# Rezoning Transportation Analysis

Petition Number: #2022-079

# Rezoning Transportation Analysis

## Transportation Summary

RZ - 200

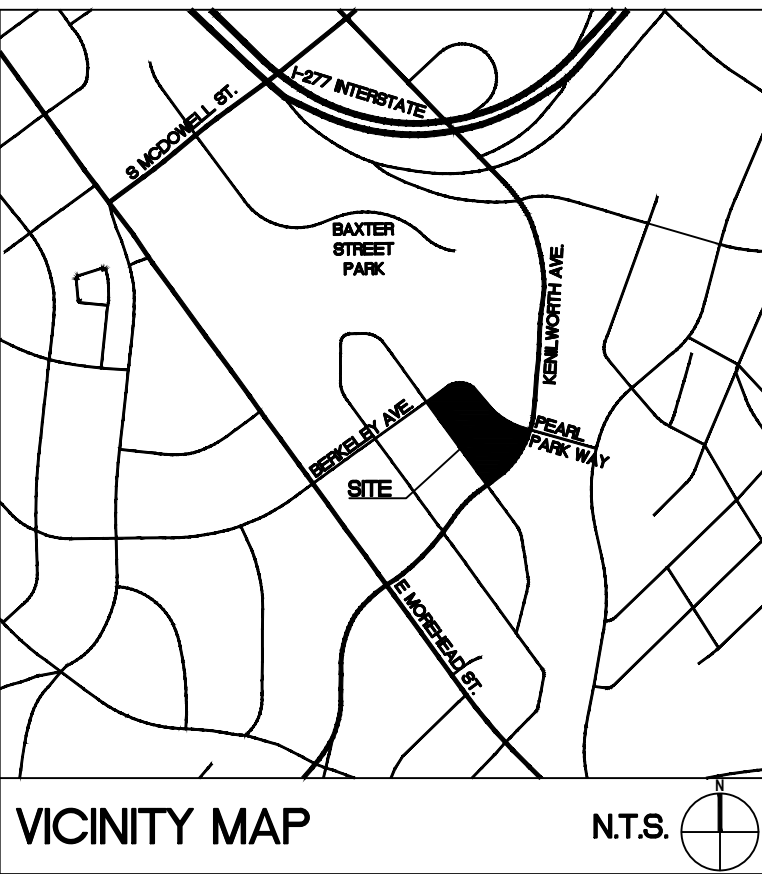
3. ~~**New Comment 11-27-23:**~~ Revise site plan and conditional note(s) to remove the proposed right in only access on Kenilworth Avenue. Access on Kenilworth Avenue does not meet driveway spacing requirements with respect to adjacent driveways, distance to signalized intersection, and conflicts with future protected intersection improvement. The site plan should be redesigned to access the site from Kenilworth using the established shared access point south of the petition.
